From: Chris Pirone
To: DMP@portlandmaine.gov; JF@portlandmaine.gov; JLT@portlandmaine.gov;
JST@portlandmaine.gov; MES@portlandmaine.gov; Thomas.Errico@tylin.com;
DSenus@woodardcurran.com
CC: AMACHADO@portlandmaine.gov; BAB@portlandmaine.gov
Date: 12/4/2013 10:34 AM
Subject: Re: Munjoy Heights: Final submission for Dec 17th PB Hearing

Fire comments:

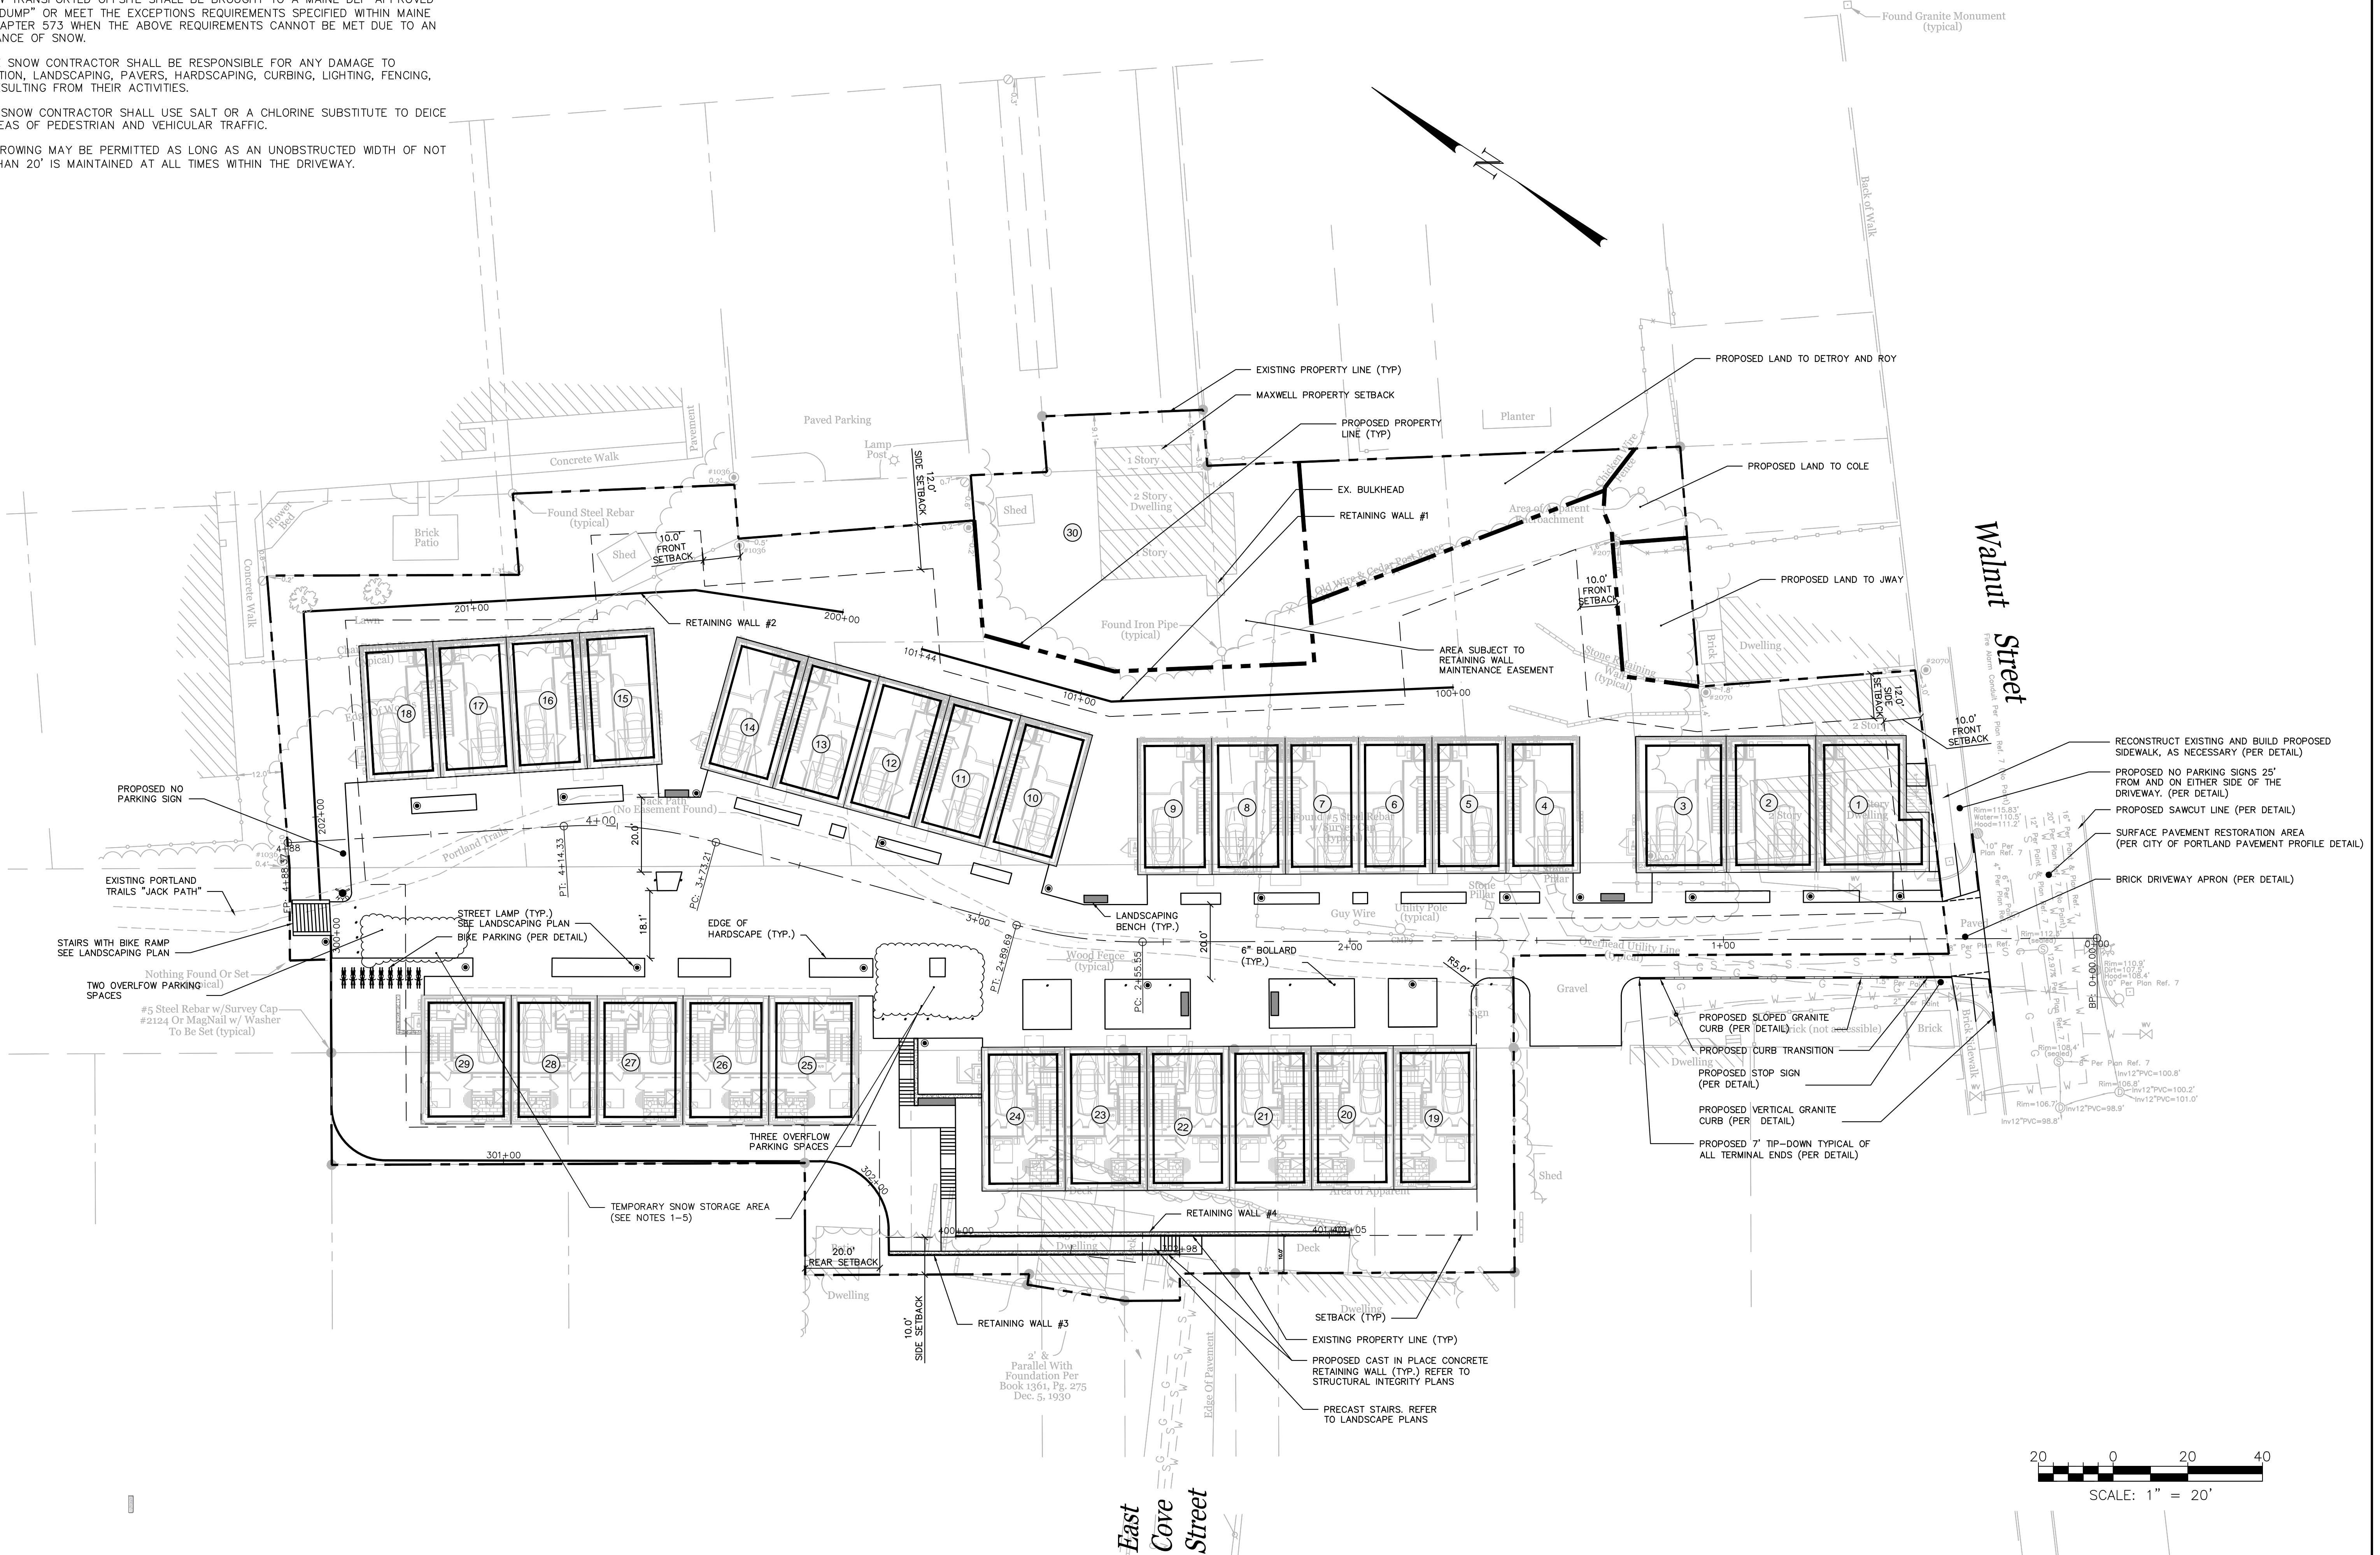
The 20' access needs to be maintained at all times. This includes no parking (fire lane) and snow removal plan. These conditions should be placed in the condo documents.
I understand this is a European street style and there will be different pavement styles but is to remain flush and able to withstand the weight of Fire Department Vehicles. As an example a fire department ladder truck sets its aerial ladder to the roof, it needs to deploy its outriggers to the edge of the access road, and road will be able to support this load.
